Please ask for: Ms Iqraa Malik
Email: iqraa.malik@terraquest.co.uk
Telephone: 01212341390
Our Ref: BN/73/21/HH
Your Ref:
Date: 17th June 2021

Application for Planning Permission for Works or Extension to a Dwelling

Development: Garage conversion to habitable use and alterations to fenestration/openings
Location: 54 Highview Road Eastergate PO20 3XB

FOR MR & MRS BOOKER		
SITE 54 HIGHVIEW ROAD, EASTERGATE, WEST SUSSEX. P020 3XB		
TITLE EXISTING ELEVATIONS		
SCALE 1:100	DRAWN AH 06/21	DRAWING NO. 04 REV

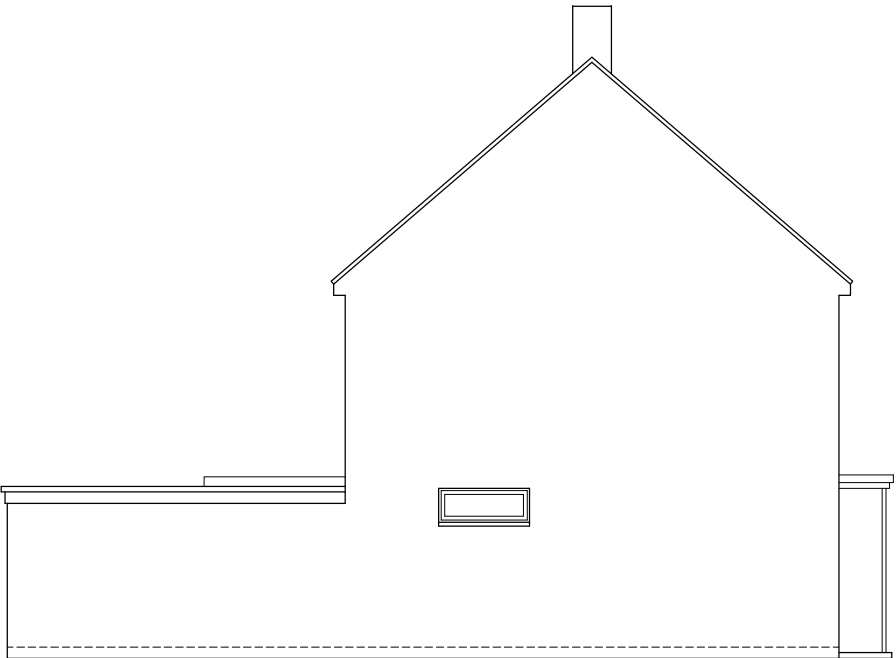
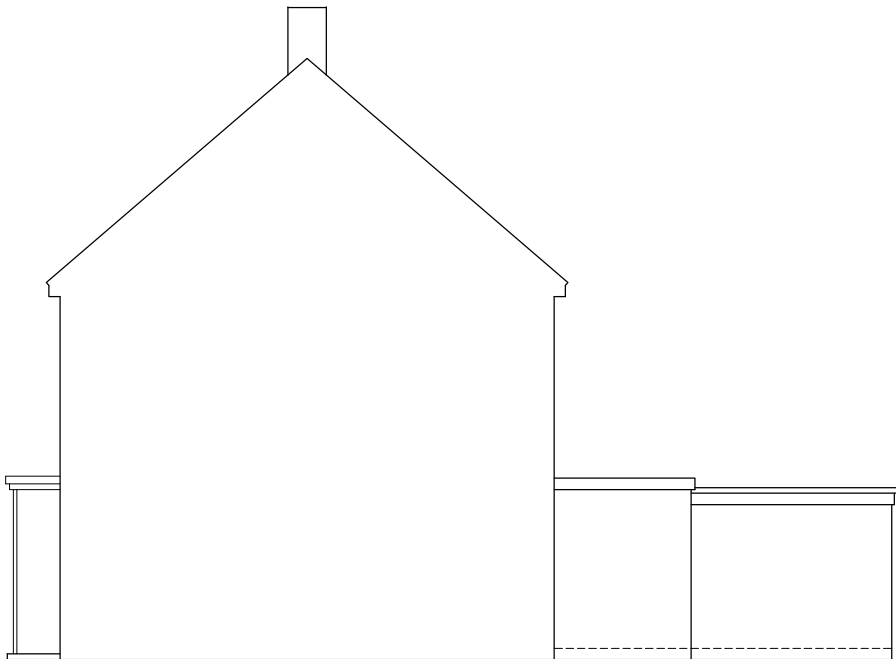
The window shown on the existing side elevation is missing from the existing ground floor plan. Please review and amend accordingly.
